26 August 2019

**Re: Application SSD 9526 Maxwell Underground Coal Mine Project**  
**Appendix H Historic Heritage Assessment**

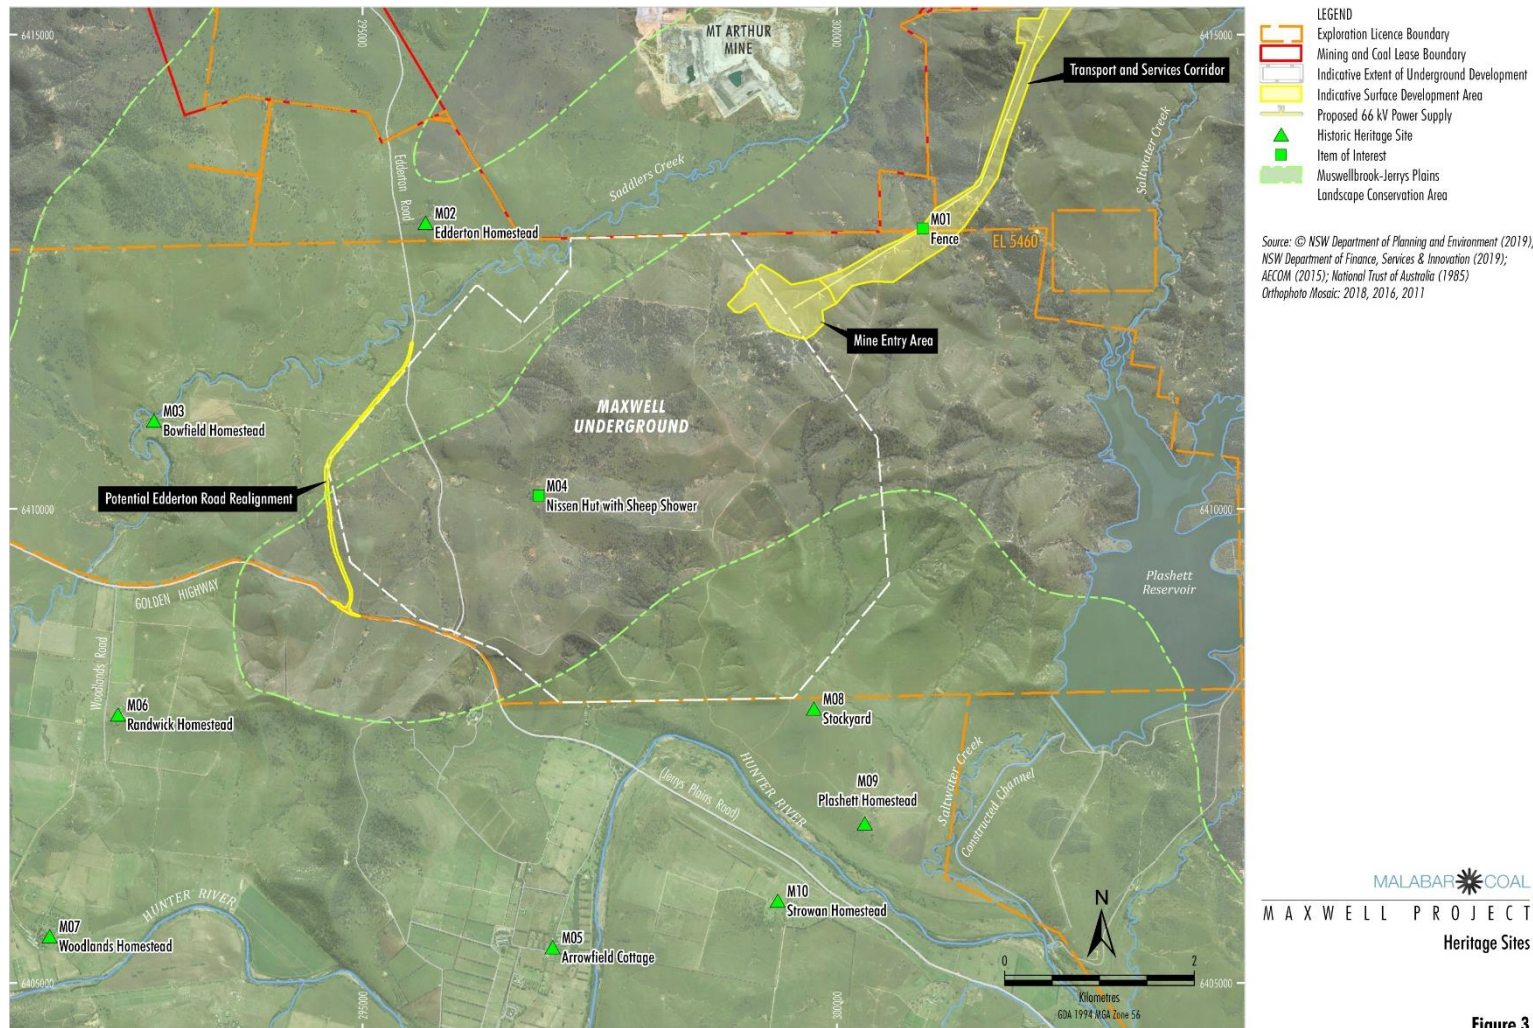
1. The assessment has relied heavily on previous reports
2. There is no map showing the impact area over Parish Maps. While the Underground covers an area occupied by large properties (which have been identified) the Transport and Service Corridor is through an area of small farms. These have not been identified.

3. Maps on pp.4-5 are about the size of a large postage stamp and are useless.
4. The assessment states that there will be very little surface impact due to the operation being underground. Longwall mining produces considerable impact due to subsidence, which I have observed first hand.

5. Edderton: While there is a lengthy description of the main building, other buildings including two houses have been neglected. One of these houses has hand cut bearers so it could pre date the main house. This part of the assessment needs a plan to provide a better understand of the relationship between the structures mentioned.

6. Bowfields: Plan needed to locate the features mentioned in the assessment.
7. Plashett: As above – plan badly needed. Further, there has been no assessment of the timber stables etc to the east of the homestead. The present poor climatic conditions would be an ideal time to attempt to locate the position of other building that must have existed on a large working station. The Historic Heritage Assessment states that the Project will have no impact on Plashett. There will unless there is an undertaking to maintain the site and complete the work started by Anglo American.
